RE: **Gold Avenue Casitas**
Revised Grading and Drainage Plan
Engineer's Stamp Date 10-27-2014 (File: K15D098)

RE: **Gold Avenue Casitas**
Grading and Drainage Plan
Engineer's Stamp Date 10-1-2014 (File: K15D098)

**Re: Gold Avenue Casitas, 2109 Gold Avenue SE
Traffic Circulation Layout**
Architect's Stamp dated 10-27-14 (K15-D098)

**GRADING & DRAINAGE PLAN**

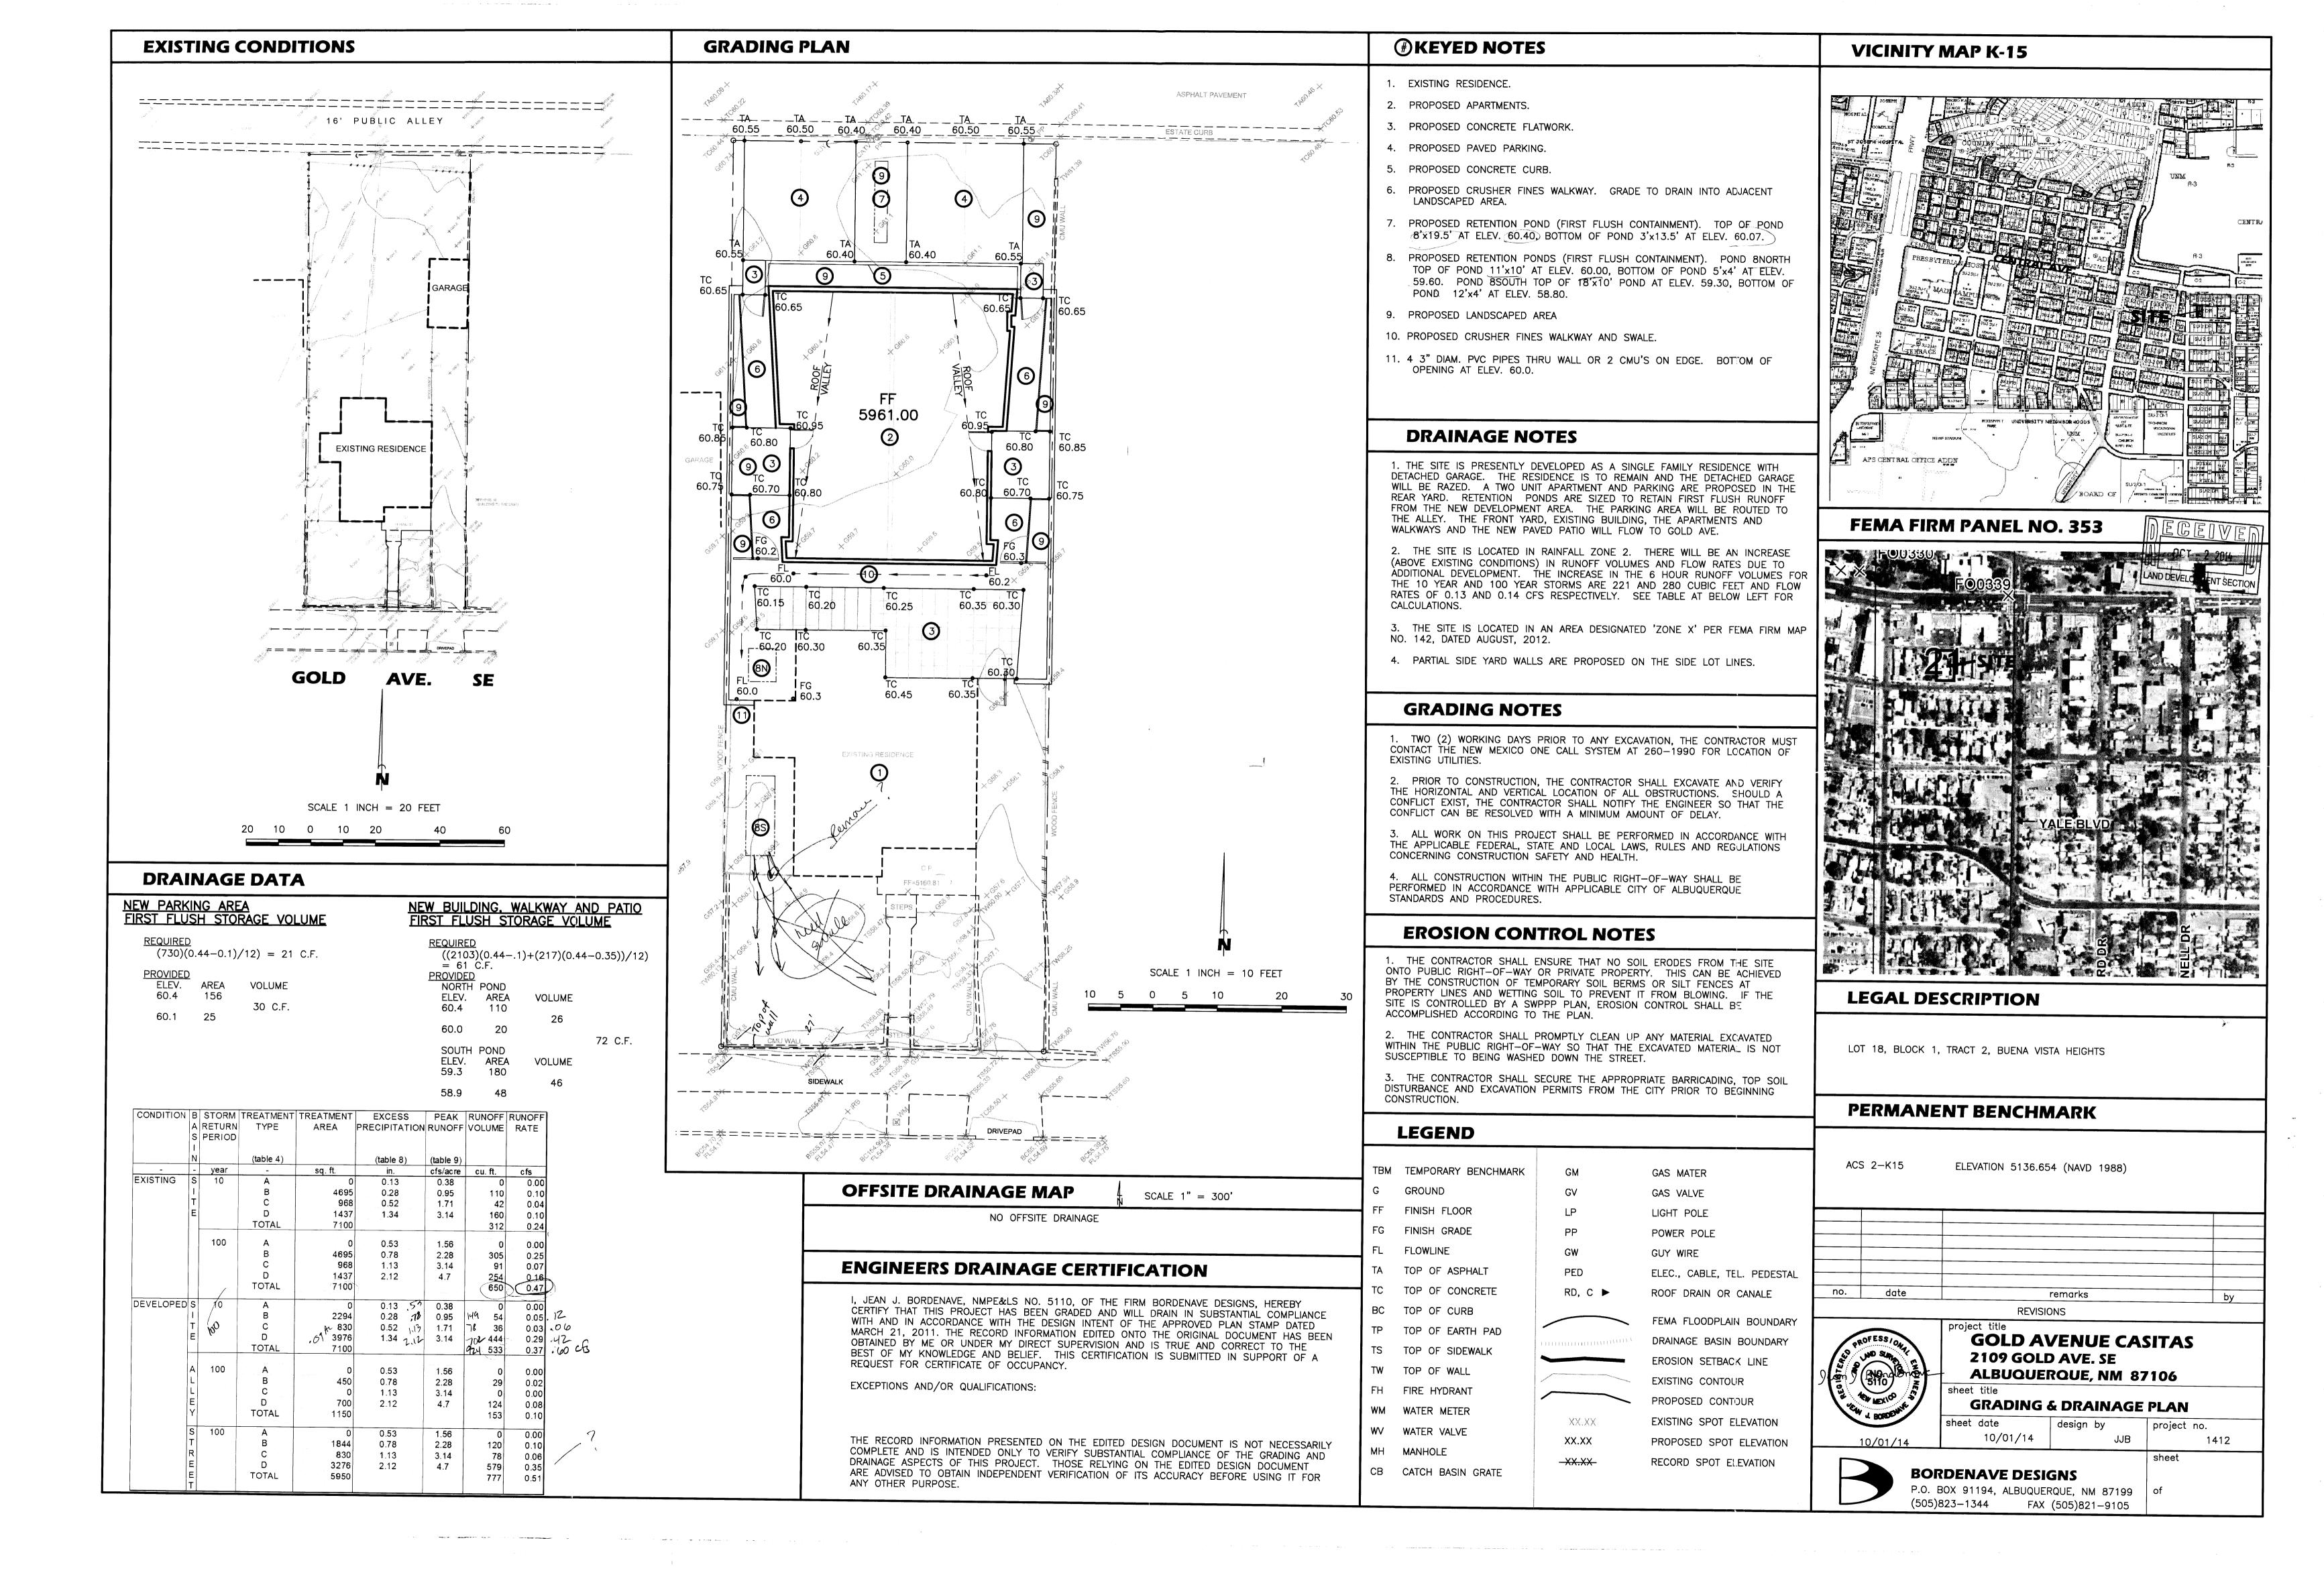
1. A drainage swale needs to extend from the 8-South pond to the drivepad to allow rainfall in excess of the first flush to discharge to the street. The fence would be removed to allow for the flow.

Per our phone conversation, the pond is intended to overflow through the slats in the fence. However, it will also flow through the fence bordering the adjacent property. Therefore, a swale still needs to be provided from the pond to the front yard to prevent overflow to the adjacent property.

- A drainage swale needs to extend from the 8-south pond to ***the front yard to prevent overflow from discharging to the adjacent property.***

As we discussed, both changes are acceptable, and we will be looking for those changes in the As-built plans.

Revision # 1 - added low CMU wall on west property line from the previously shown new CMU wall south of pond 8N to the north end of the existing rock wall to direct overflow from Pond 8S to front

Revision # 2 - Changed Keyed Note 4 from "paved parking" to "compacted crusher fines parking".
